re: Geotechnical Responses to City Comments
Proposed Canoe Storage Building
795 Tweddle Road – Ottawa

date: February 8, 2023

file: PG6038-MEMO.01

DRAWING PG6038-1 – TEST HOLE LOCATION PLAN

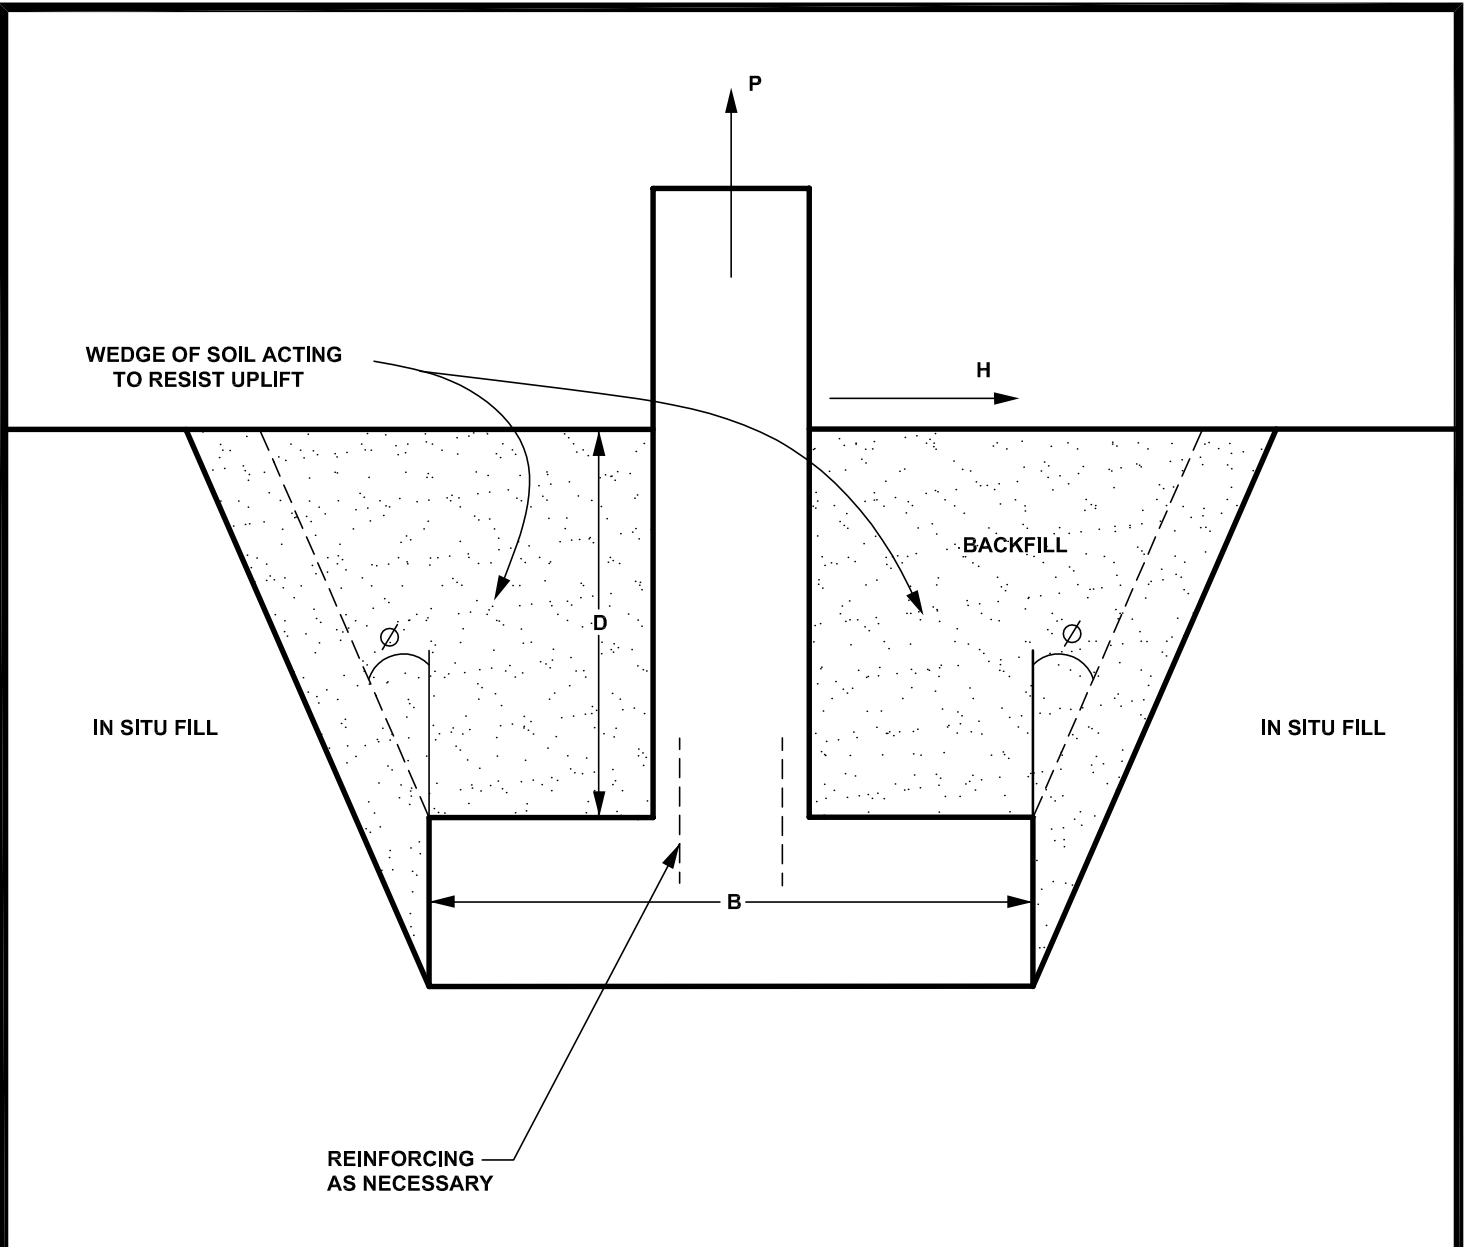
Comment B2: *Location of proposed structure has moved, boreholes are no longer within the proposed building area.*

Response: The borehole is located approximately 15 m from the new building location. Given the geological history of this beach, where dredged sand was used to create the beach, the subsurface conditions are not considered to vary significantly across this distance, and the existing borehole is still considered to be representative at the new building location.
